City of Albuquerque, New Mexico
Development Review Board

Re: Coors Road Panda Express – DRB Review
NM 448 (Coors Road) and Old Airport Road (northeast corner)
Response To Comments

The following are the responses to the plan check comments received on 09/28/22:

C01.0

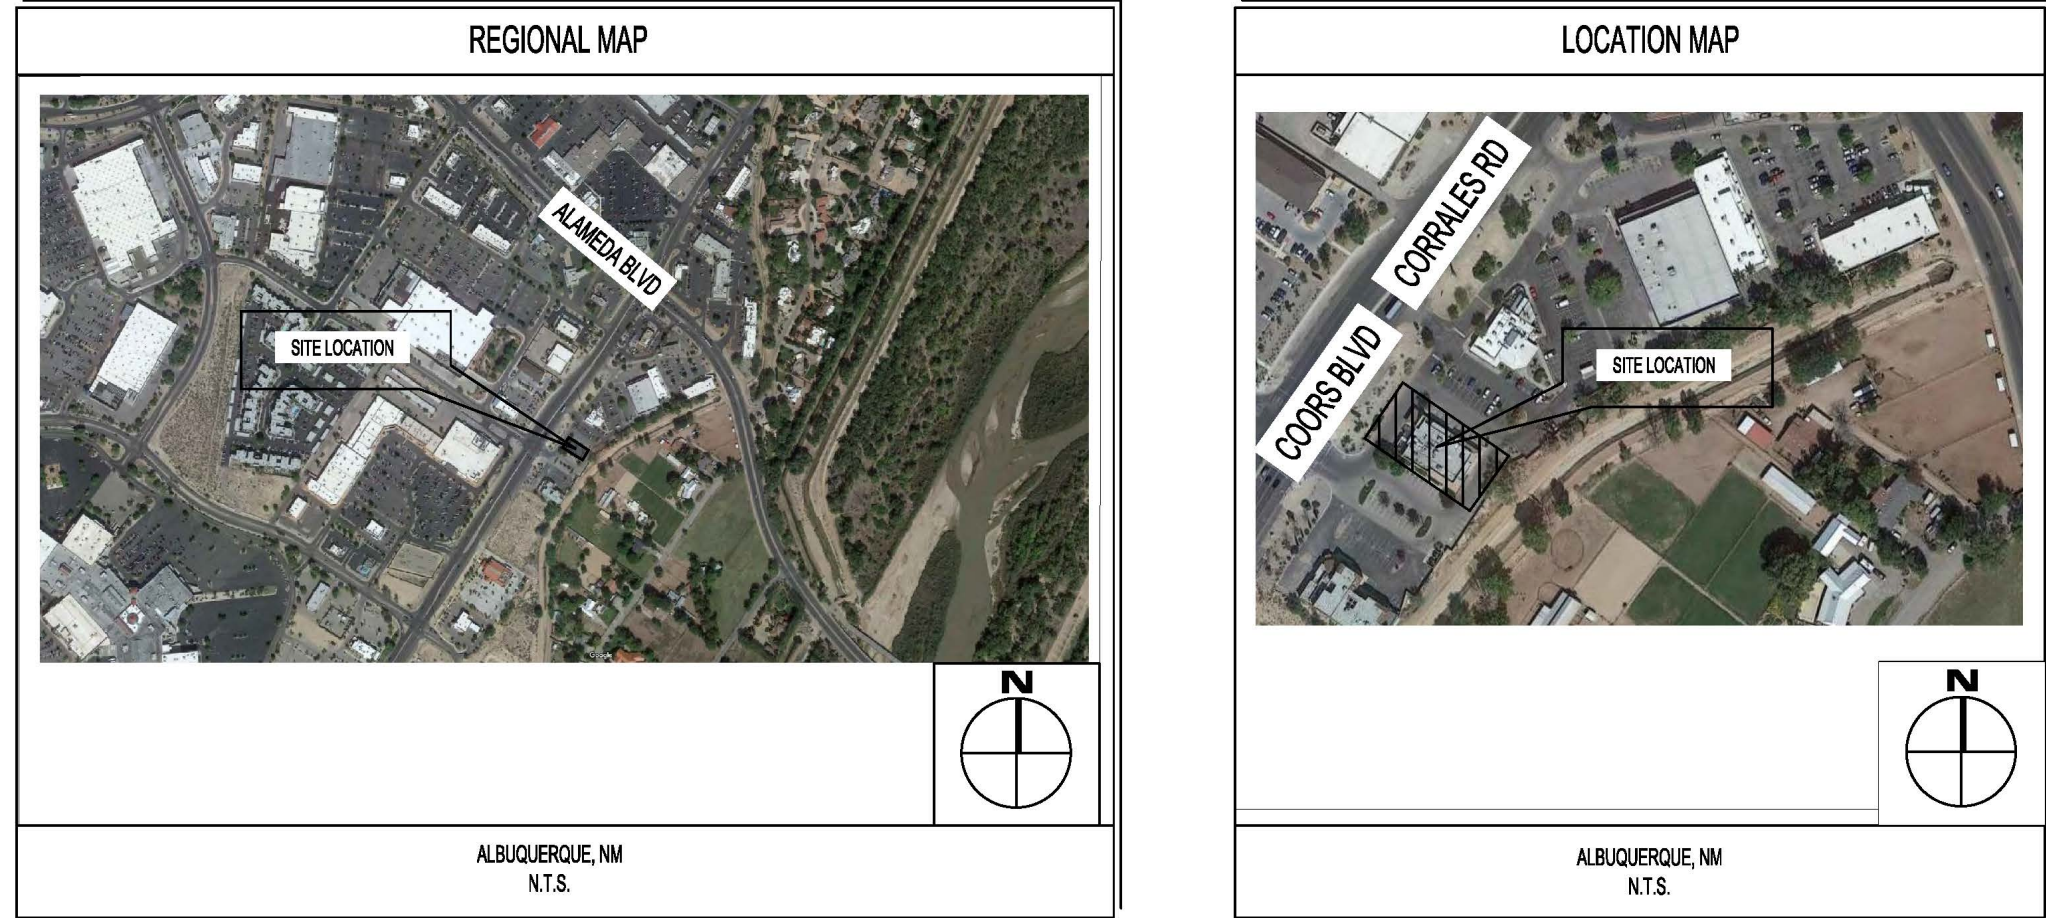
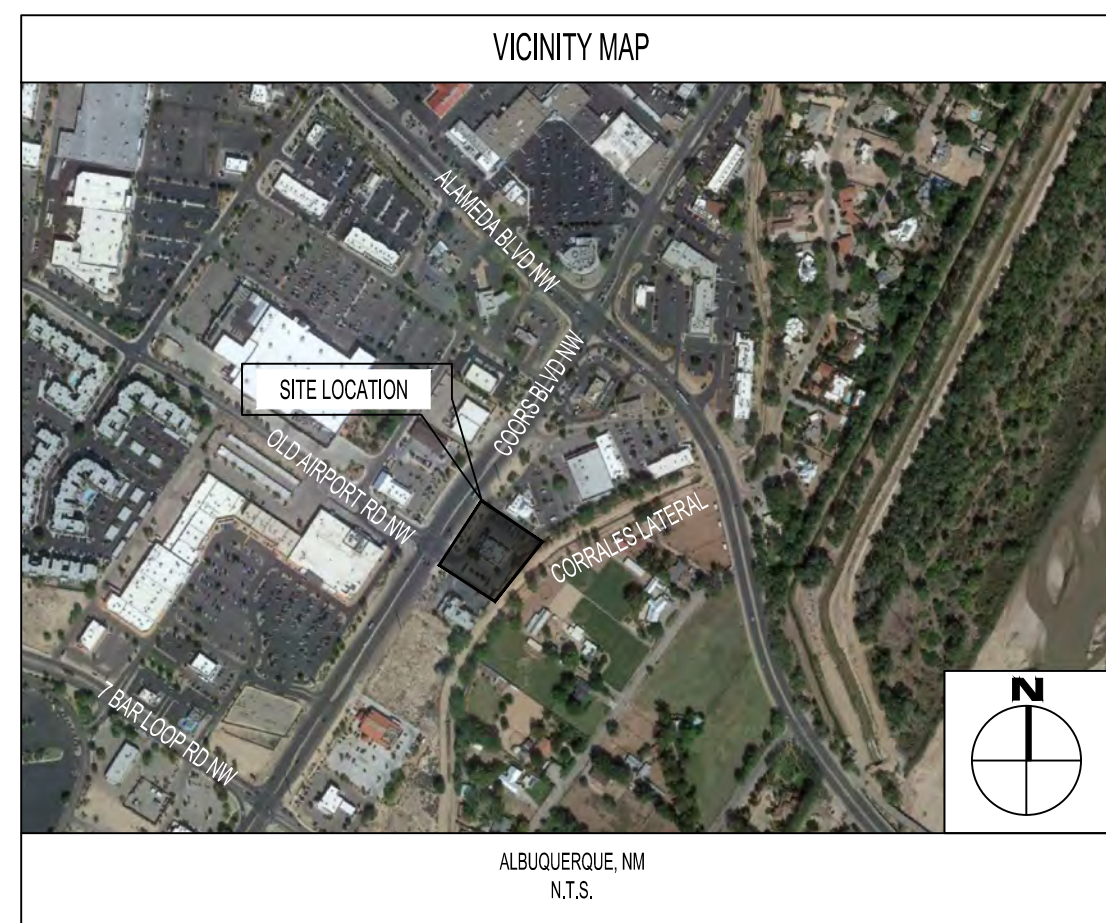
- 2. Due to the amount of work that NMDOT is requesting, a COA work order is needed and this shall also be added to note #6 on C01.0.**

Response: Note #6 on C01.0 has been updated to state that a work order must be submitted to the City of Albuquerque prior to the start of construction. Said work order will be coordinated with the DRC once DRB approval is granted.

C03.0

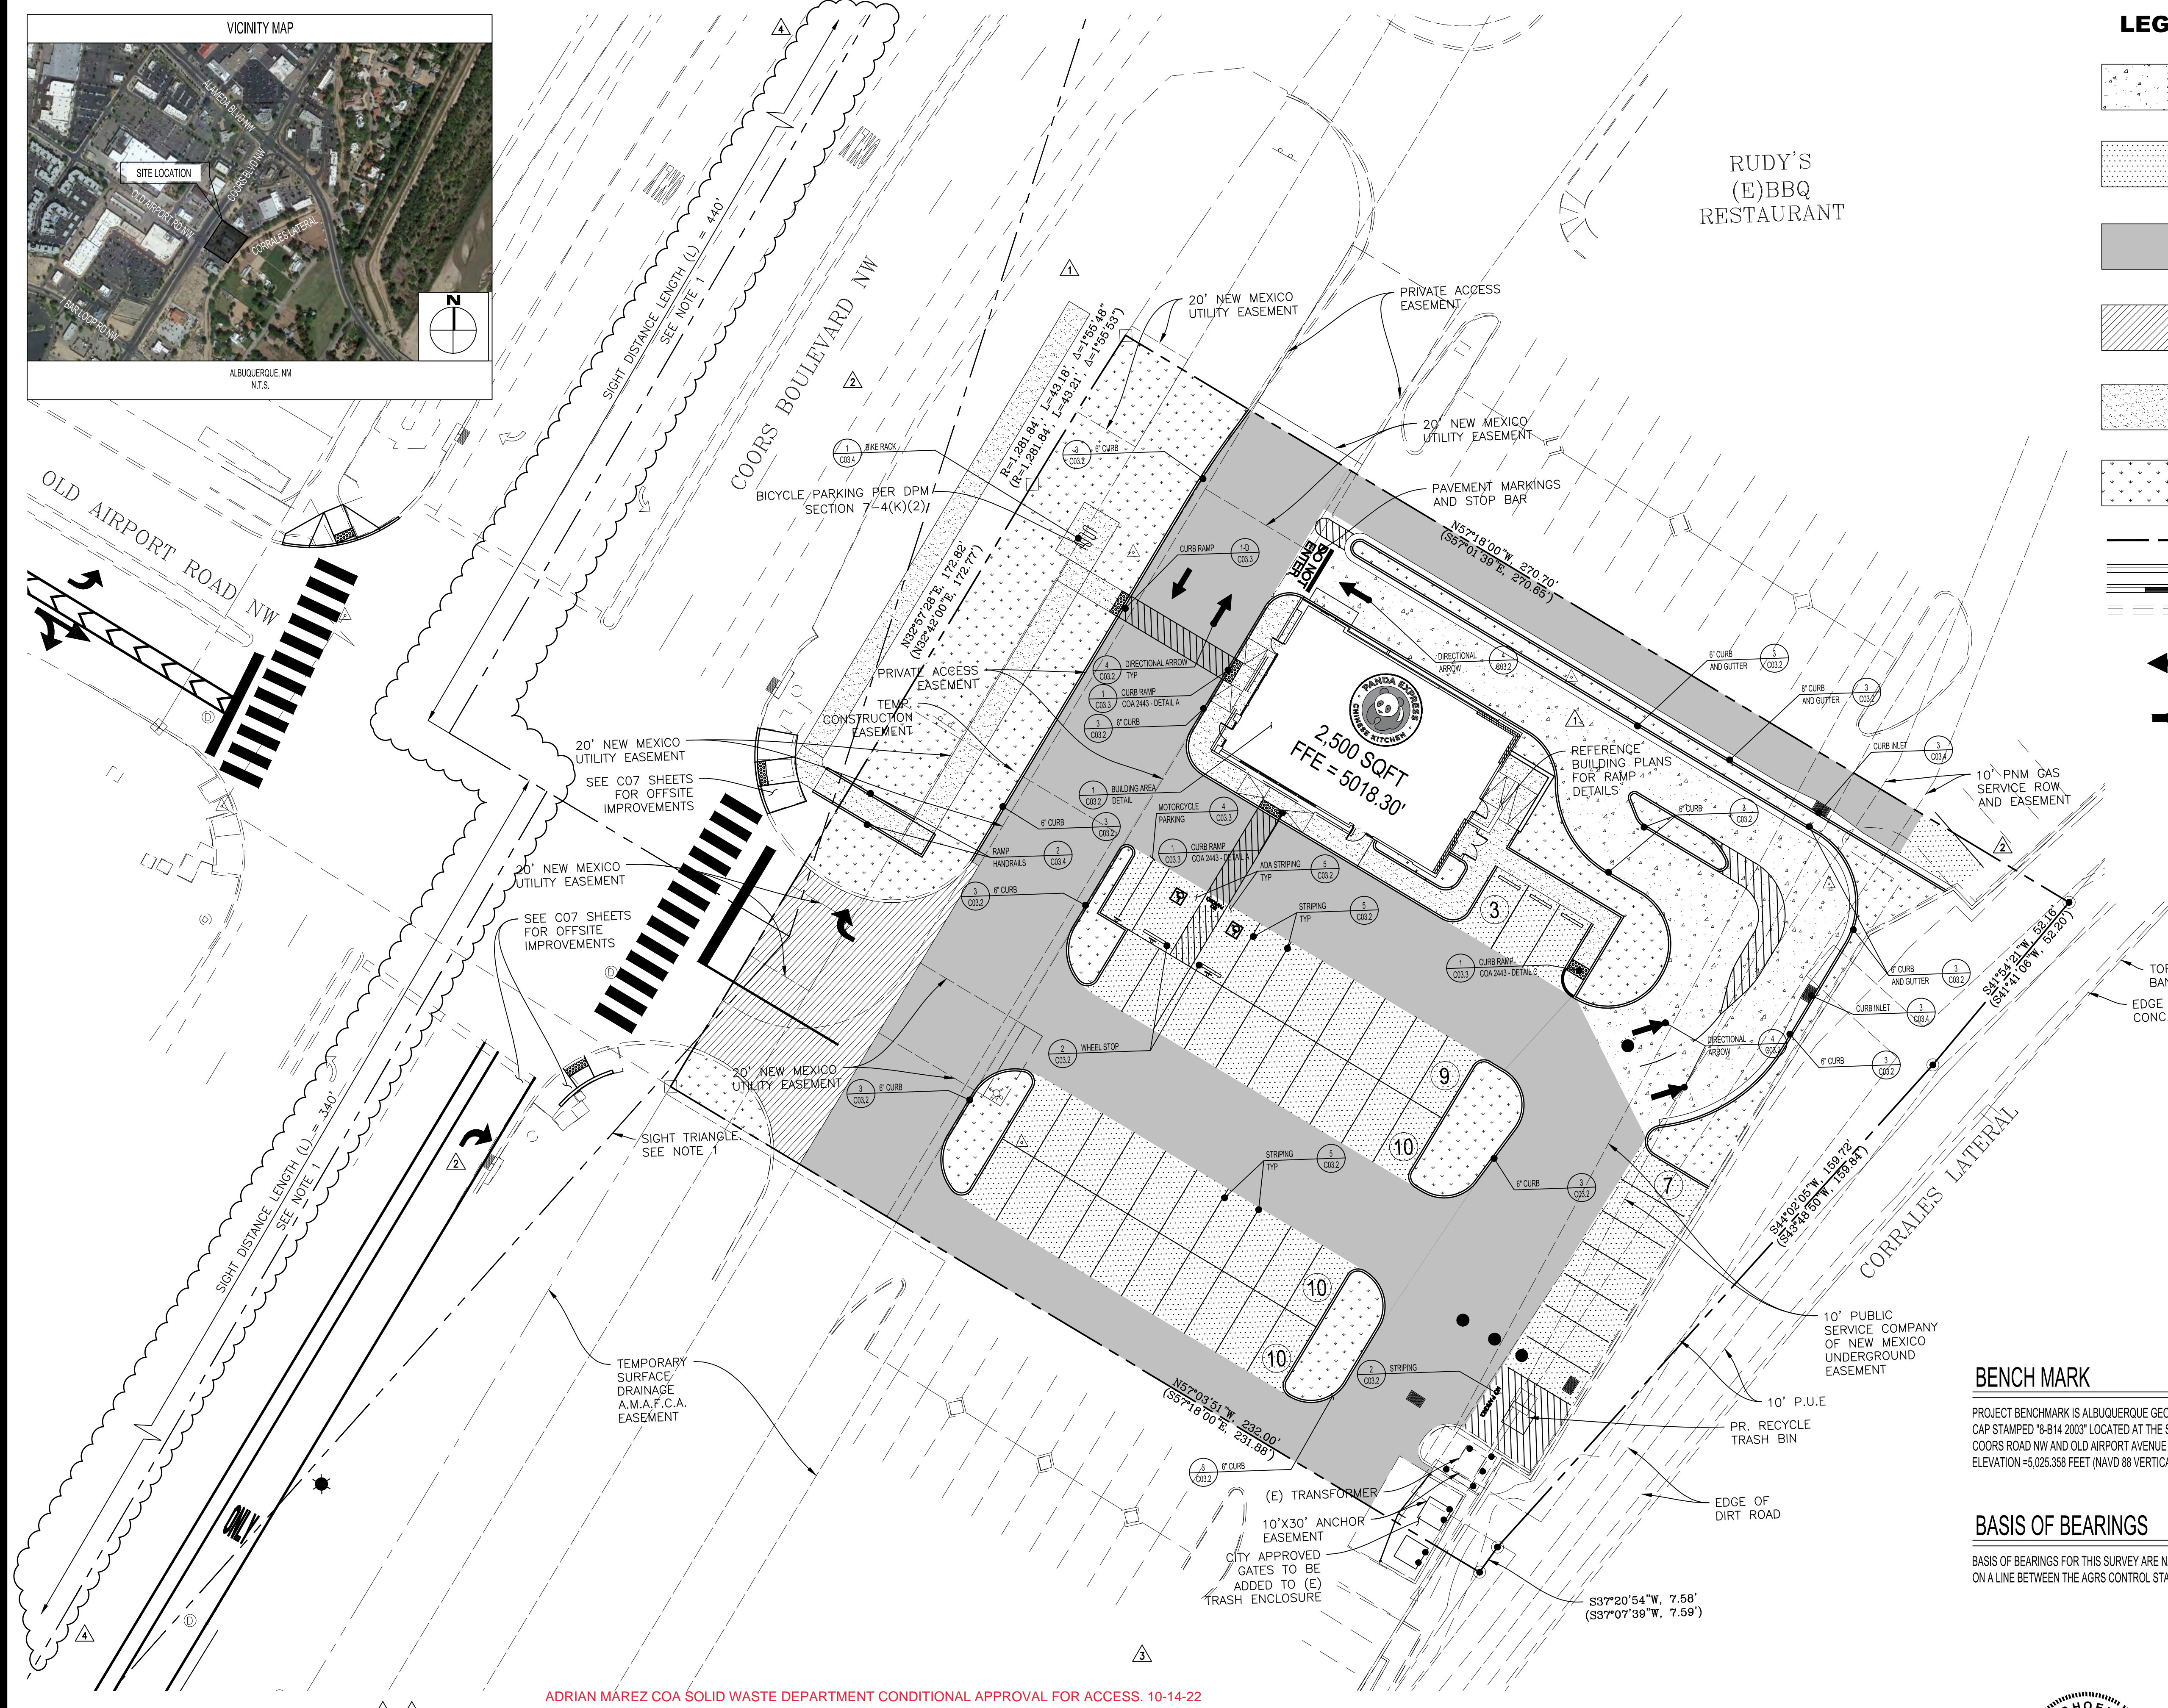
- 4. The clear intersection sight distance triangles shown at the entrance appear to be based on driveway clear sight and not intersection sight distance. Please use intersection sight distance shown in the new DPM Chapter 7 page 7-114.**

Response: The clear sight triangles have been updated per coordination with Ernest Armijo, see sheet C03.0

C03.1

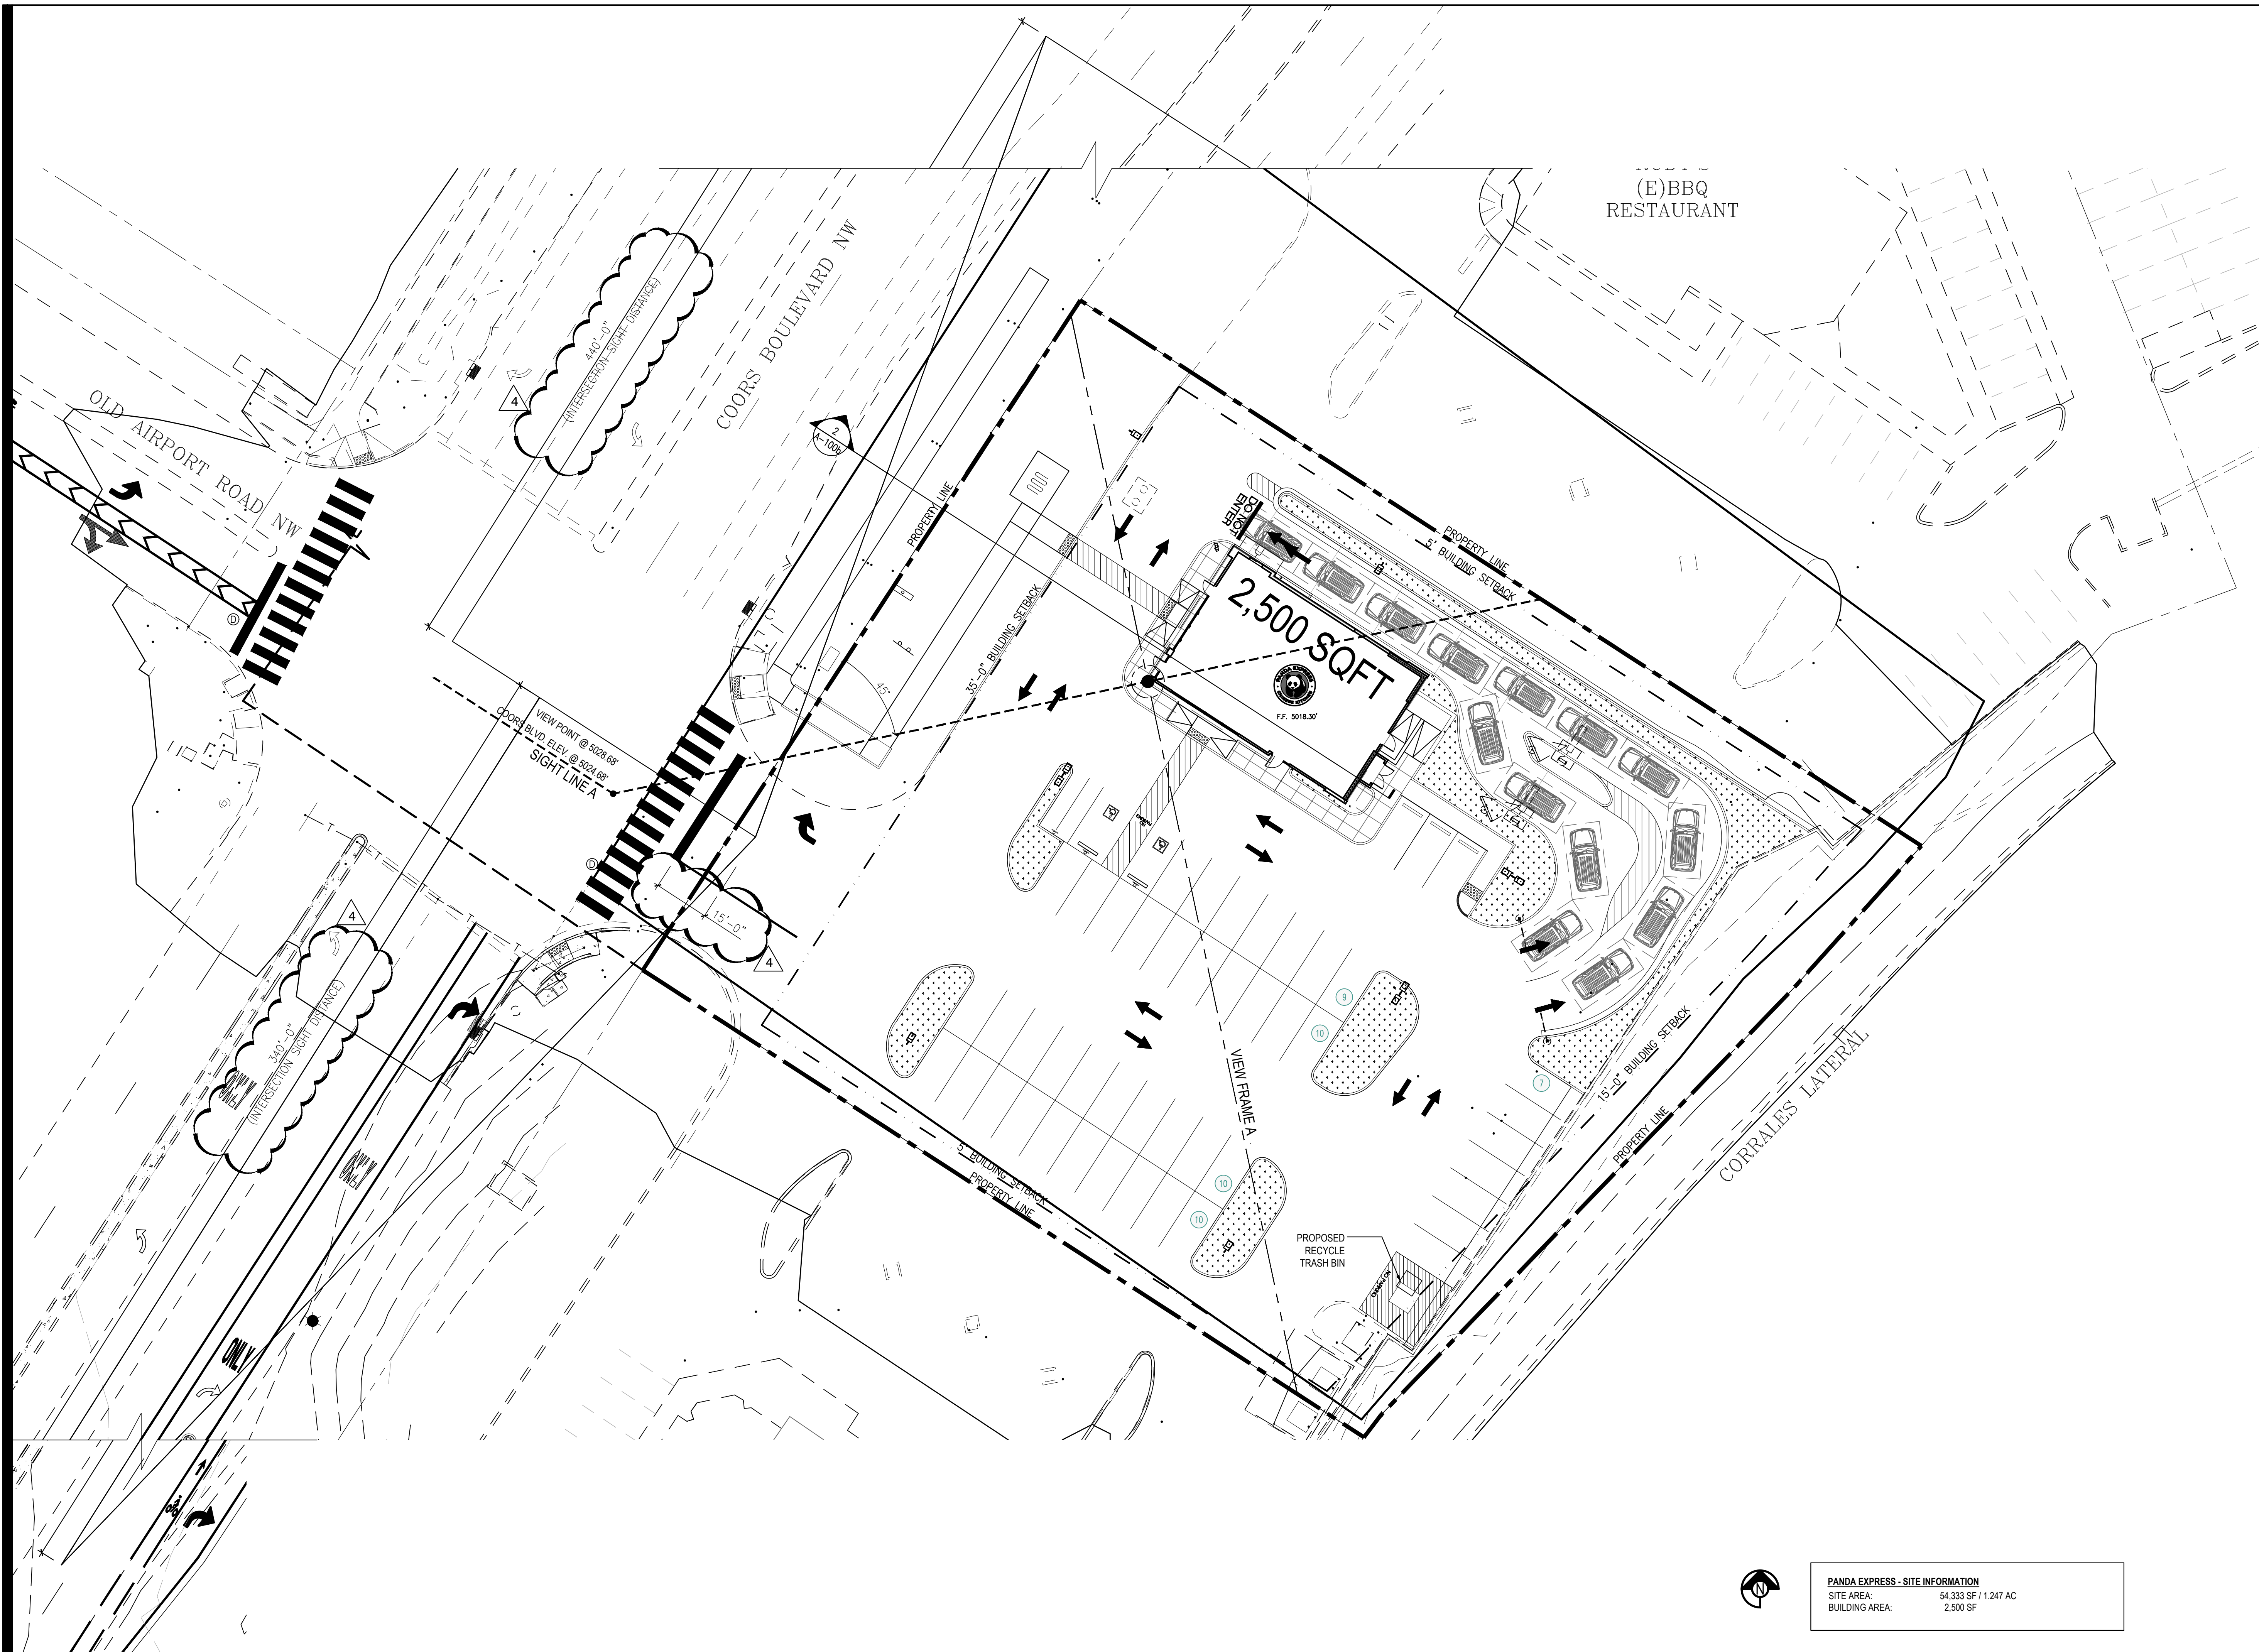
- 3. Include the driving aisle width along the east side of the site. It is called out as “Varies”, so please call out width at various critical points on the site plan**

Response: Multiple widths along the driving isle have been added, see sheet C03.1
